Ribbon Development

1 Wheat Rd
Darling Harbour
SSD-5397

Submission to
Department of Planning
& Infrastructure

October 2013

SCALE @ B1	DRAWN	CO-ORD	REVIEWED	APPROVED
1 : 200	JDB	PS	PS	CB
PROJECT NUMBER	DRAWING NUMBER	REV		
A004409	ARC-HSL-DA-1153	B

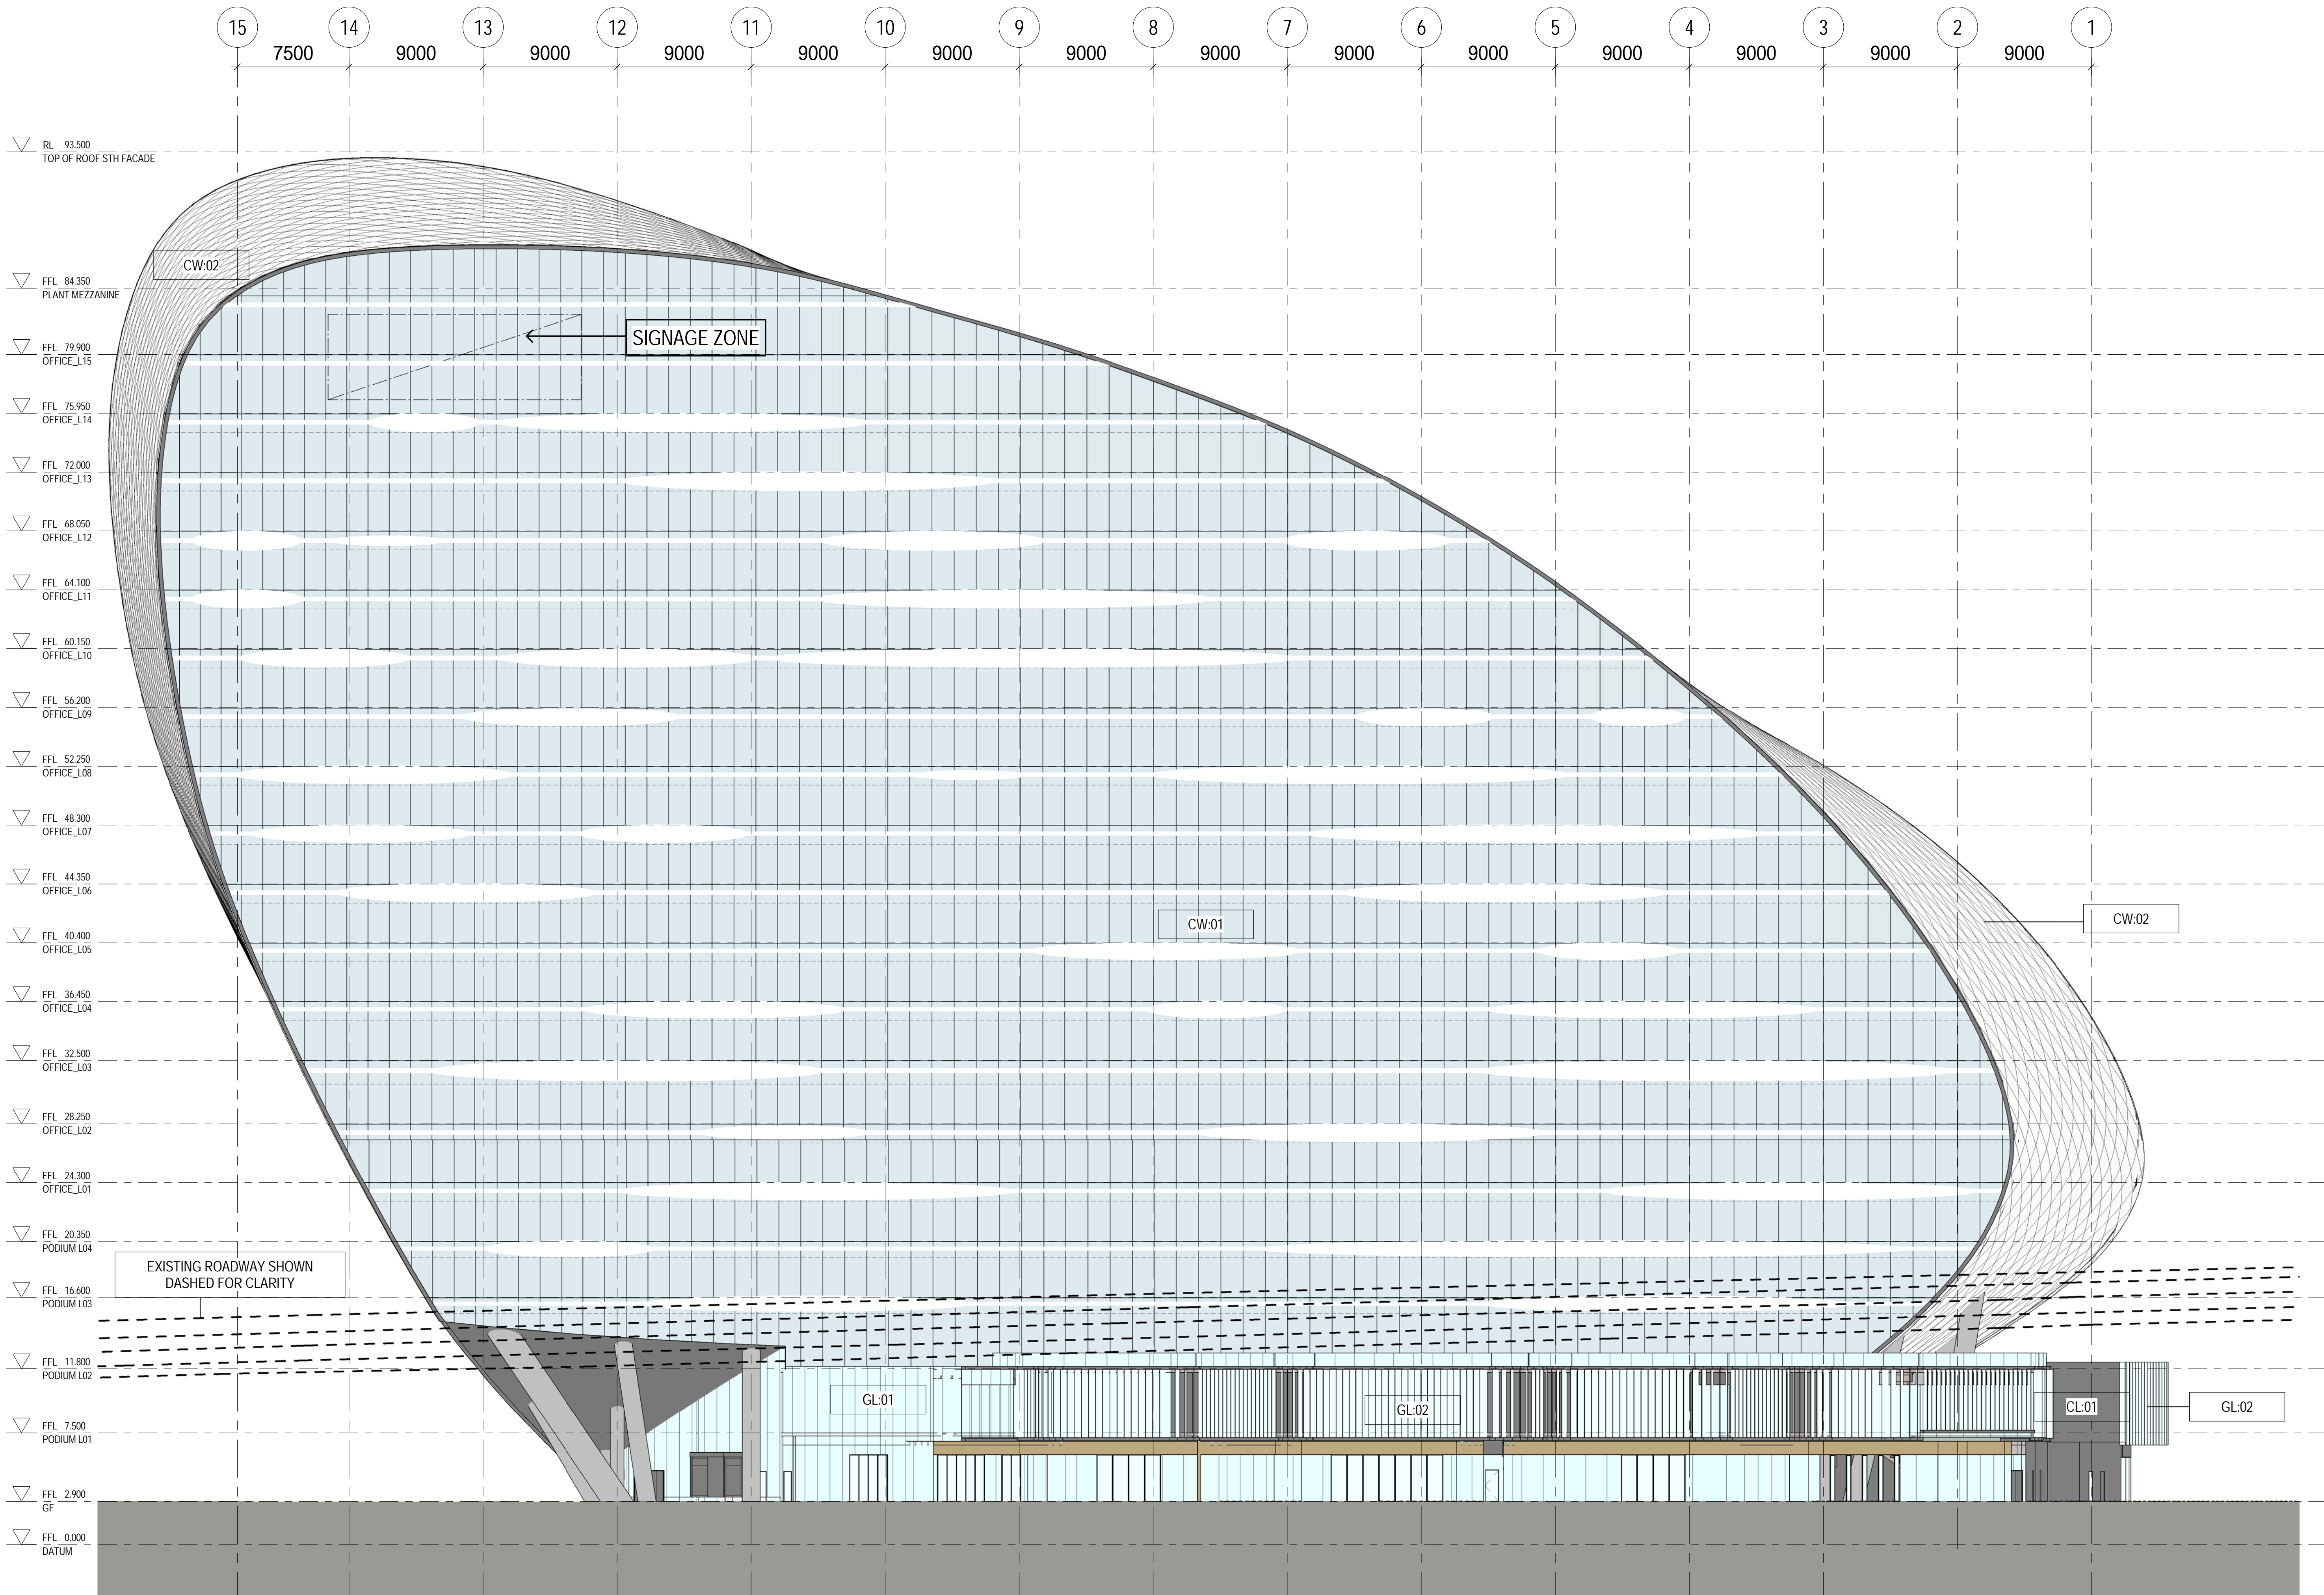
There are 35 architectural plans submitted as Appendix A of the Environmental Impact Statement (EIS). It is noteworthy that none of the architectural drawings explicitly show the cantilevered portion of the building in a manner which would, to a reasonable person, allow an understanding that the eastern portion of the building, rising 90.6m in height, was to be cantilevered 18.5m over Harbour Street.

The only drawing which suggests the building is constructed over the roadway is the roof plan because of the proximity of the proposed building to the adjacent Energy Australia City Central Zone Substation (**Figure 11**) on the eastern side of Harbour St.

It is considered that the majority of plans are insufficiently dimensioned to facilitate a comprehensive understanding of the scale of the development such as the length of the development and the width of its eastern and western elevations as well as its proximity to the adjacent Energy Australia Substation.

It is considered that the majority of plans and elevations of the development do not satisfactorily show the relationship of the development to the site boundaries.

NORTH ELEVATION_

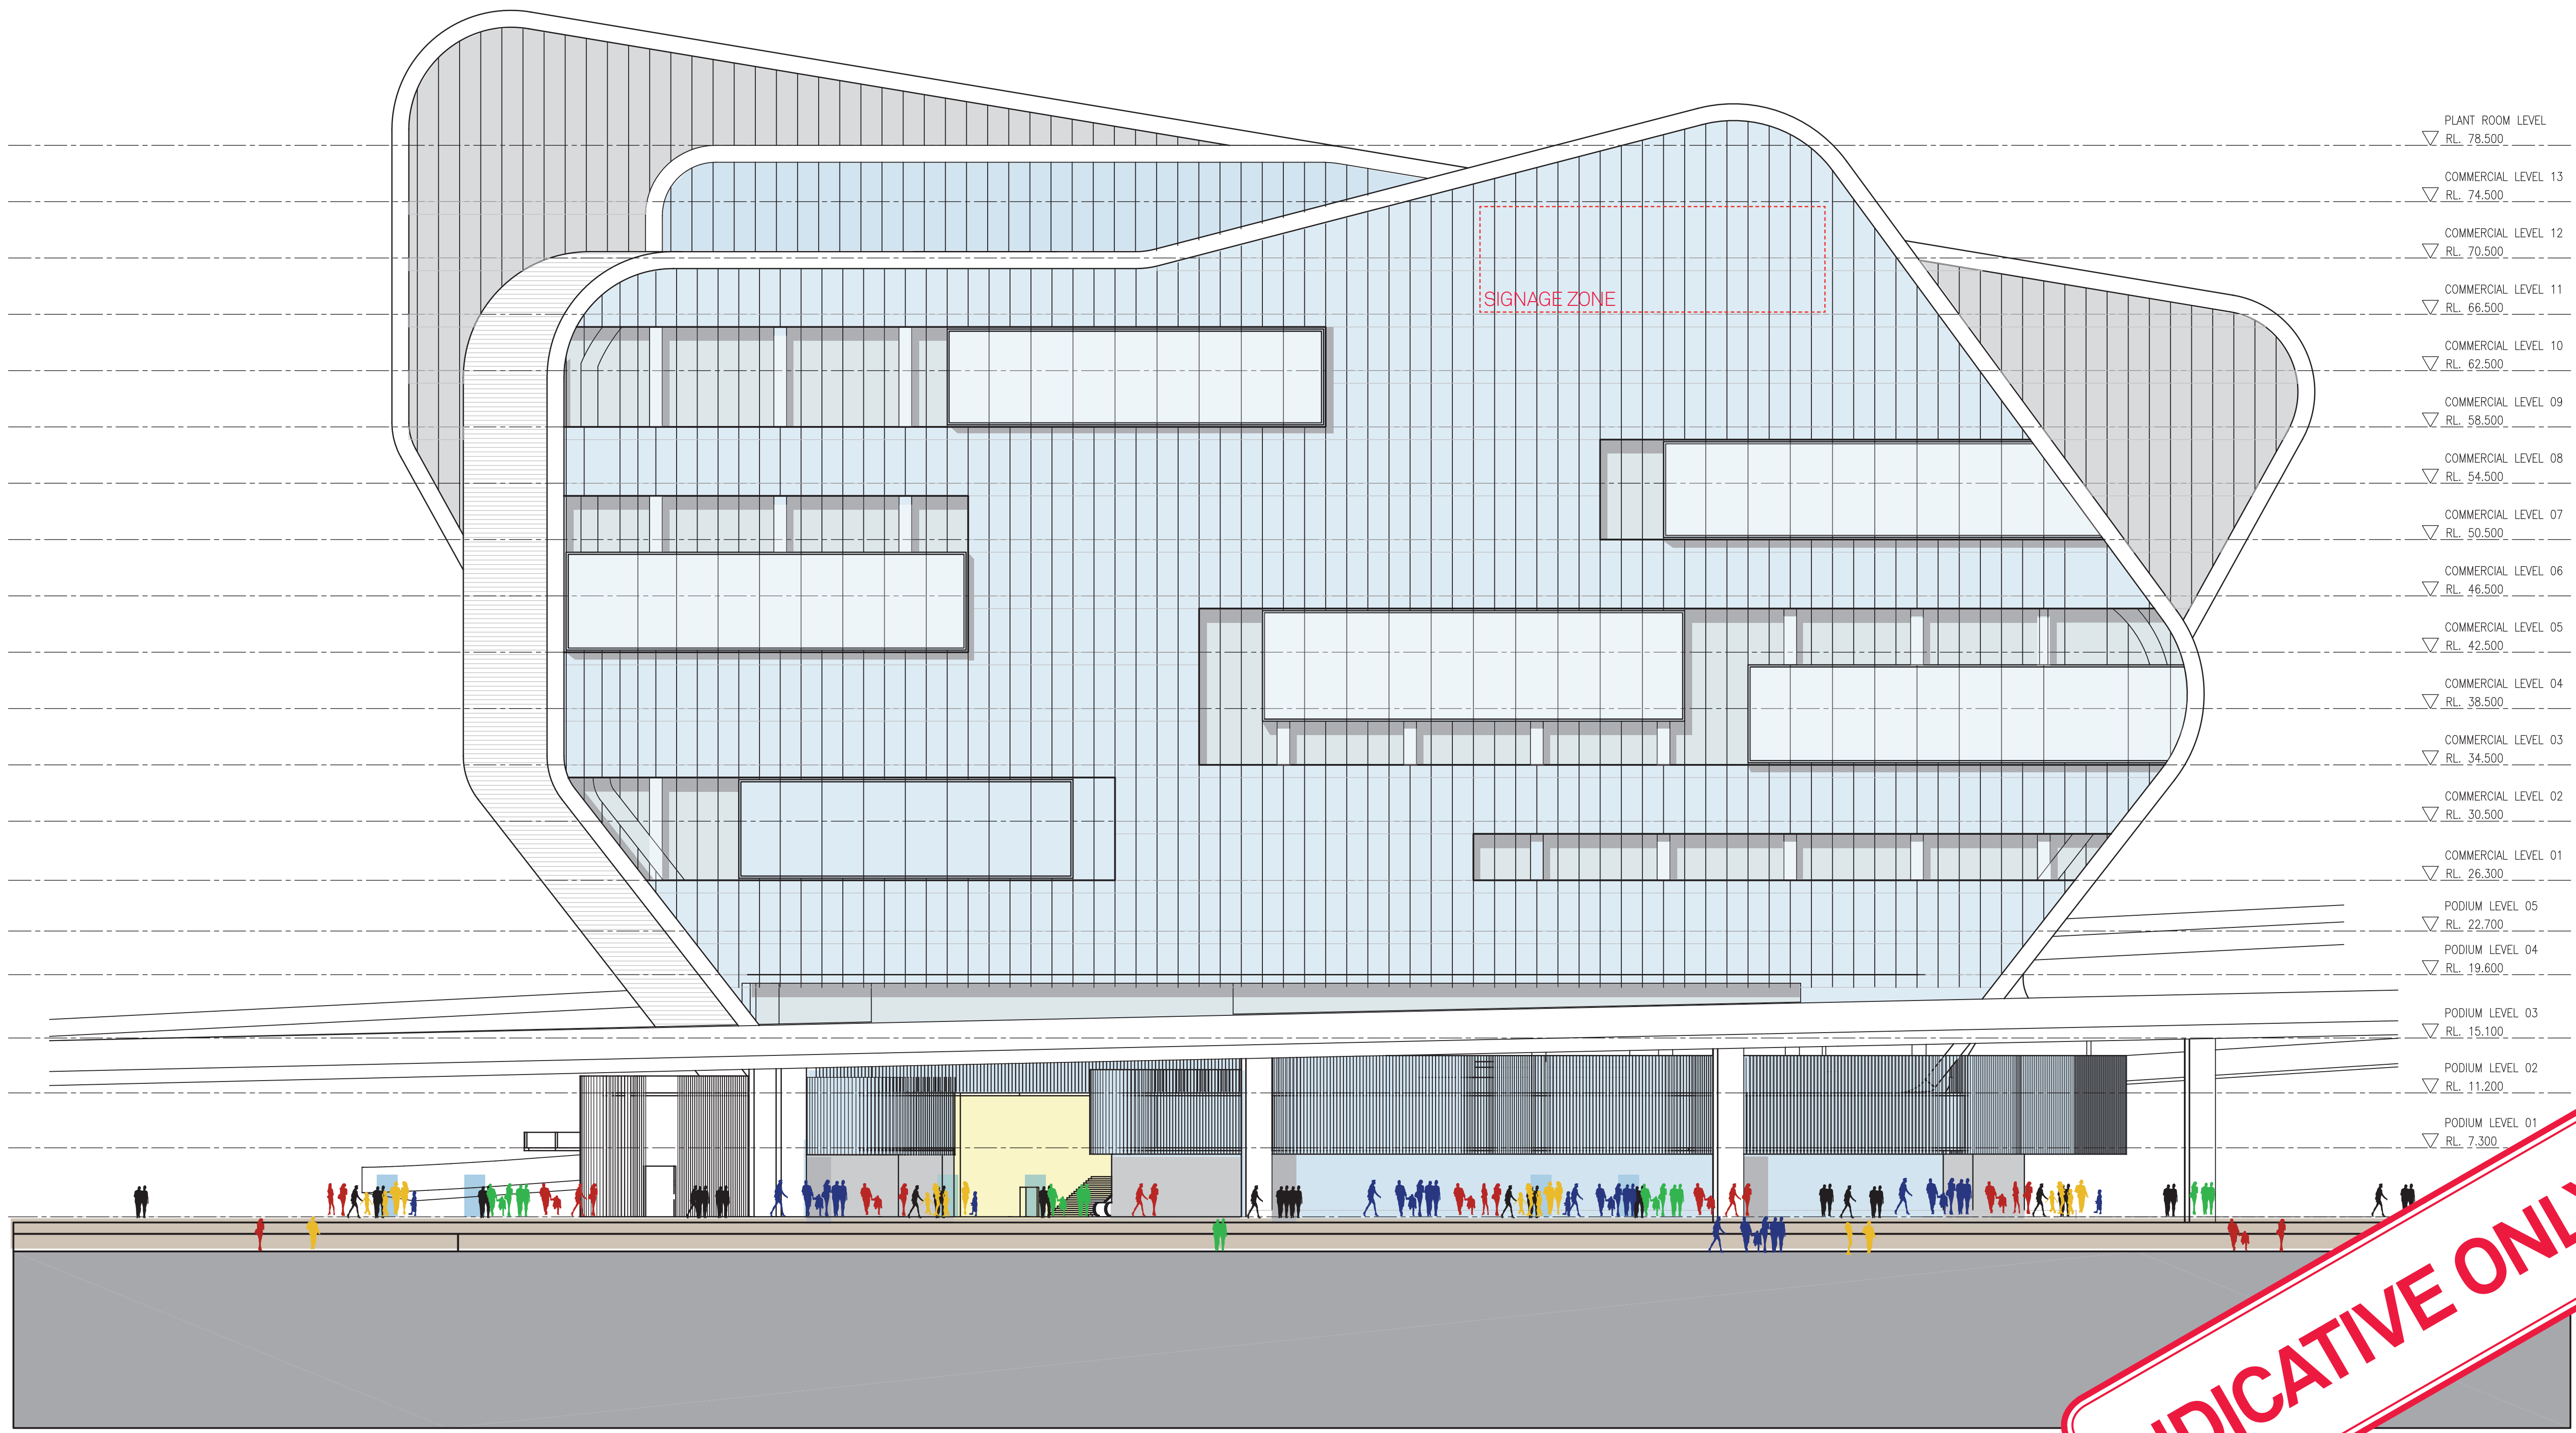
An indicative scheme was submitted with the request for DGRs. The northern elevation of that scheme is reproduced in Figure 1.

Relevant to matters to be discussed later, the indicative scheme appears to be located totally within its site boundary.
